Planning Inspectorate
MeridianSolar@planninginspectorate.gov.uk

Reference: OR-0012797/01
Customer reference: EN010169
06 October 2026

Meridian Solar Deadline 2: Comments on Relevant Representations Report and other documents submitted at Deadline 1.
Meridian Solar Farm

This response constitutes the Environment Agency Deadline 2 submission.

Project Title			
Meridian Solar Farm			
Map Title			
Environmental Statement Appendix 11-3 Figure 1-4: Illustration of Solar Panel Flood Mitigation Design Parameters			
Scale @ A3	Version	Drawn	Reviewed
1:35,000	0	LL	AK

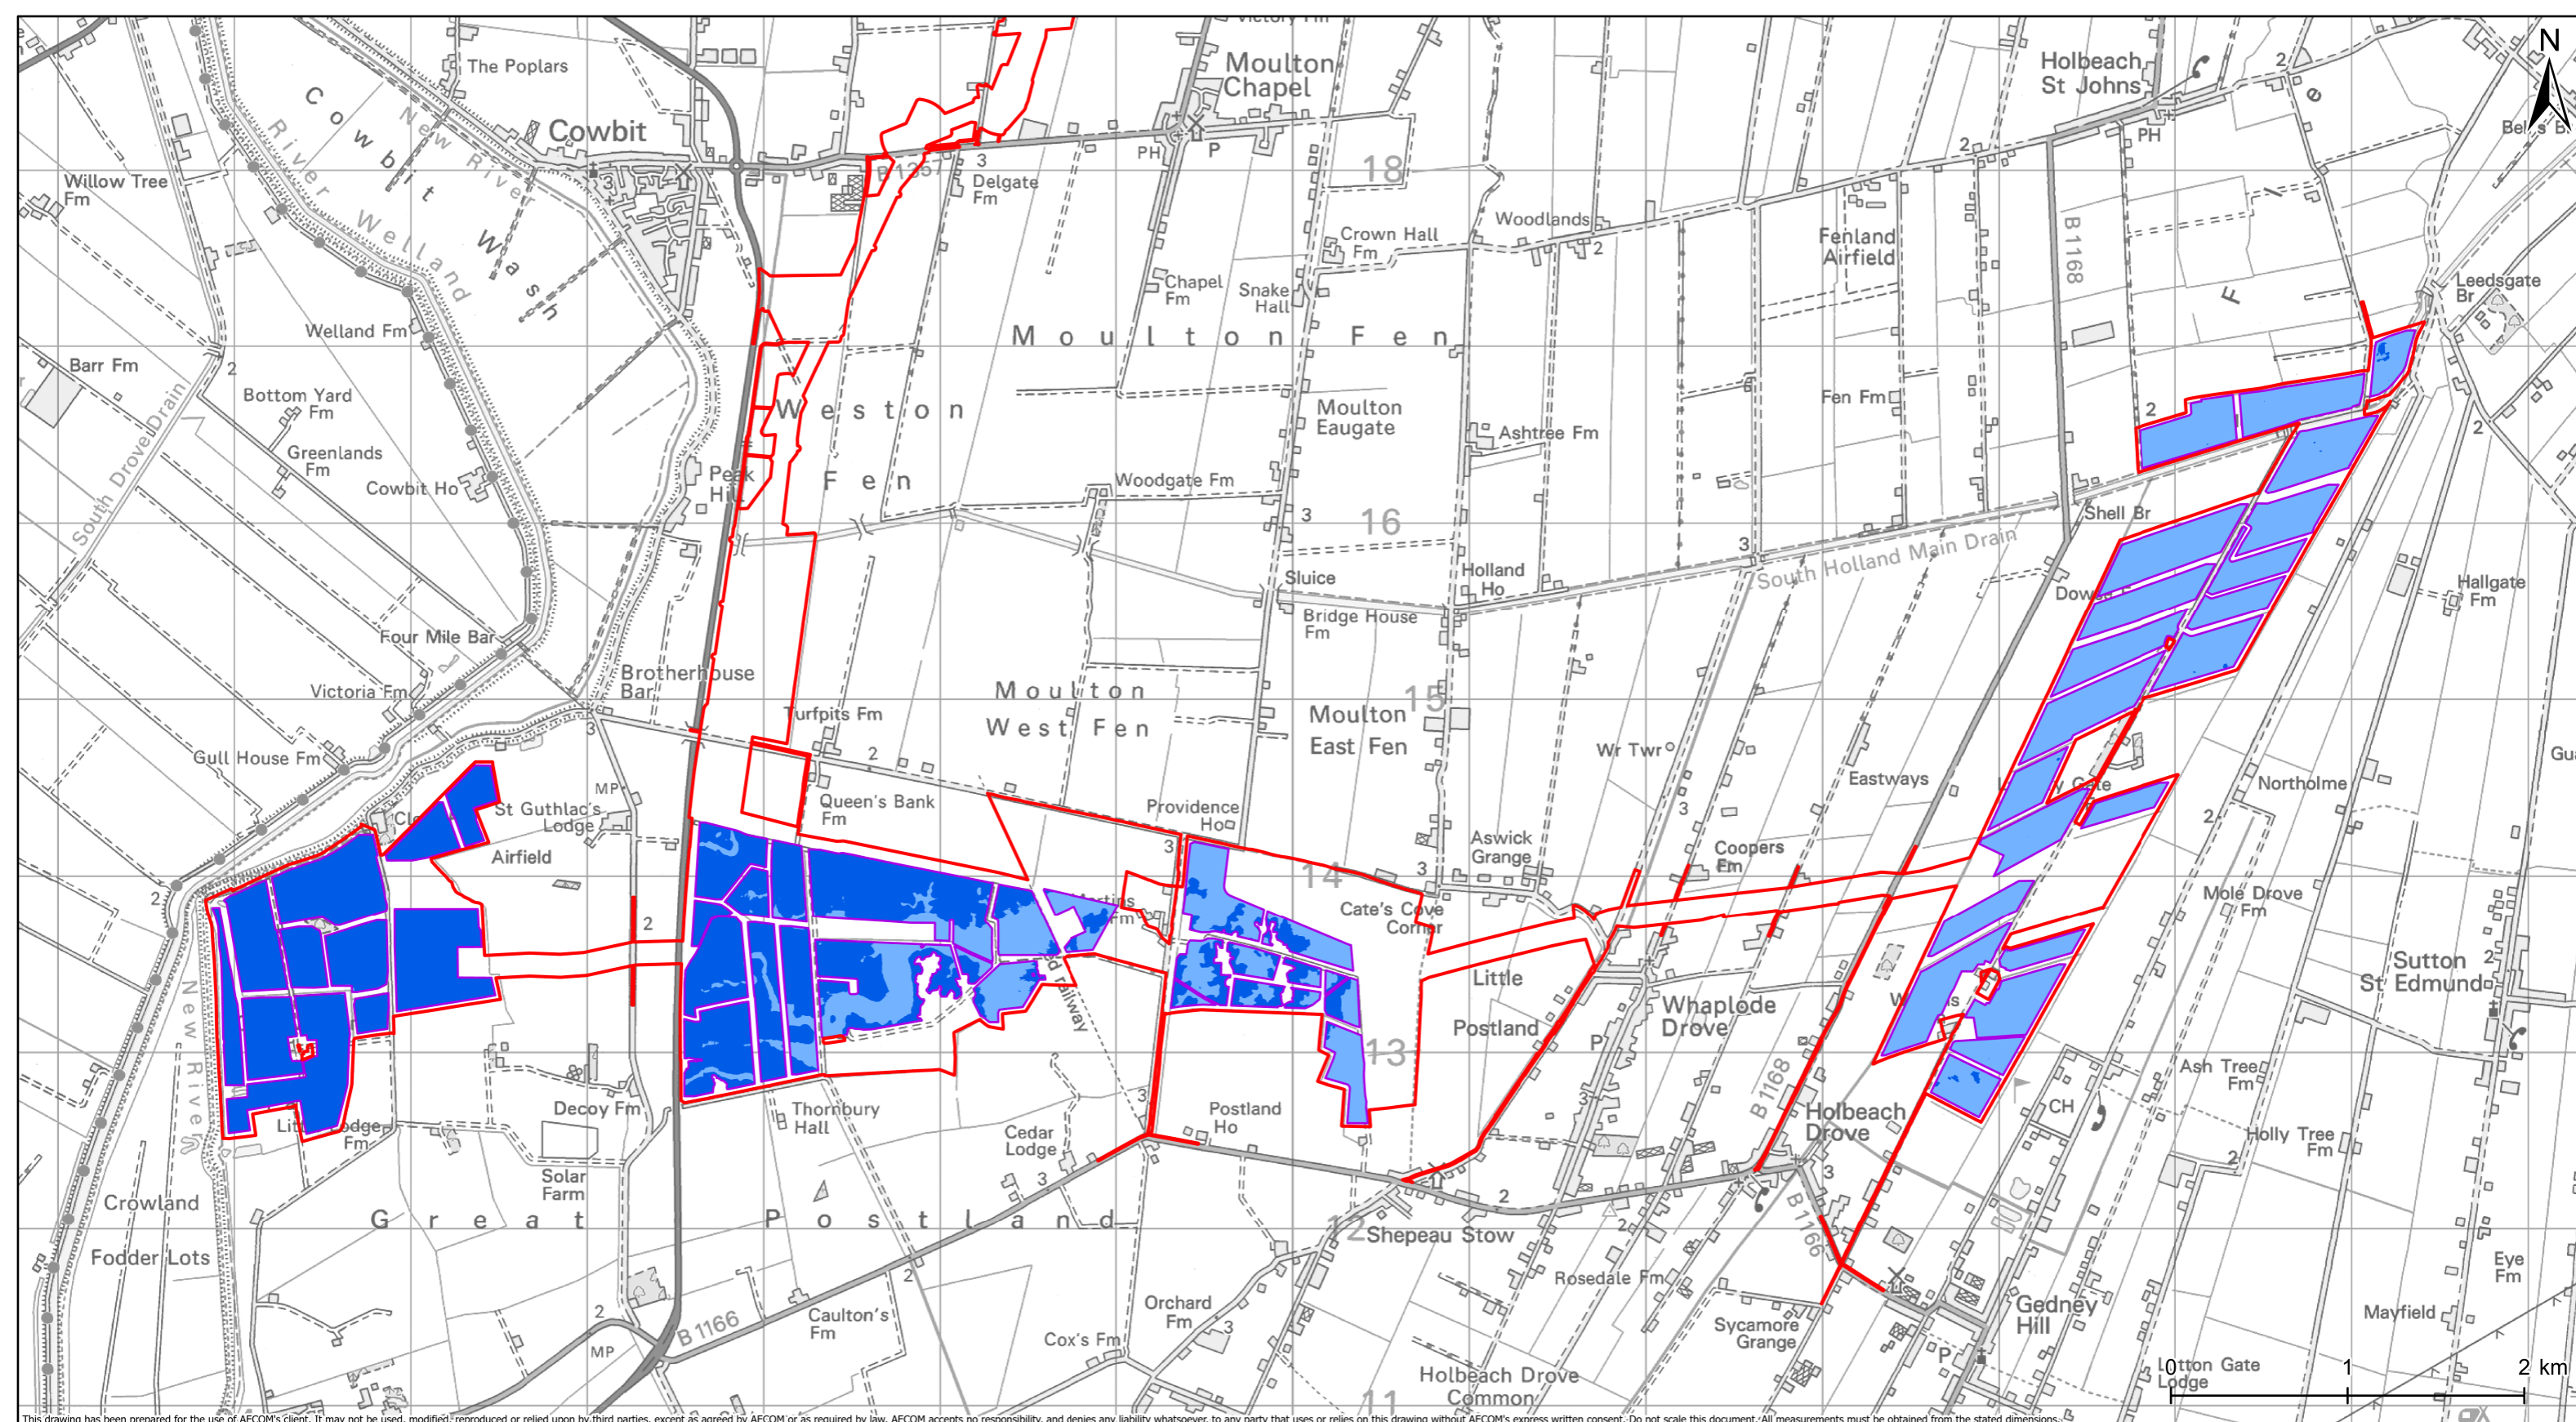
Topic	Matter Raised	Applicant's Response	EA Response
	• Clear, consistent plans showing all proposed bunding and flood mitigation measures	Figure 1-4: Solar Panel Flood Mitigation Design Parameters located in ES Appendix 11-3 Annex D (Doc Ref. 6.3 Rev 2) illustrates the solar panel flood mitigation design parameters across the Site. The figure identifies areas where panels will be installed at a minimum height of 0.8m above ground, as well as areas where panel heights vary between 0.8m and 1.3m above ground, measured from the base of the panel. These ranges are categorised as Band 1 and Band 2 to distinguish between the different panel height requirements. The bands are defined by the hydraulic modelling outputs, based on the maximum (worst-case) flood depth mapping across each assessed catchment and the required freeboard of 0.3m where this is possible to achieve within the maximum height parameter for the solar panels. Figure 1-5: Solar Station Flood Mitigation Design Parameters also located in ES Appendix 11-3 Annex D (Doc Ref. 6.3 Rev 2) provides clear mapping of the different mitigation requirements for solar stations	Resolved.
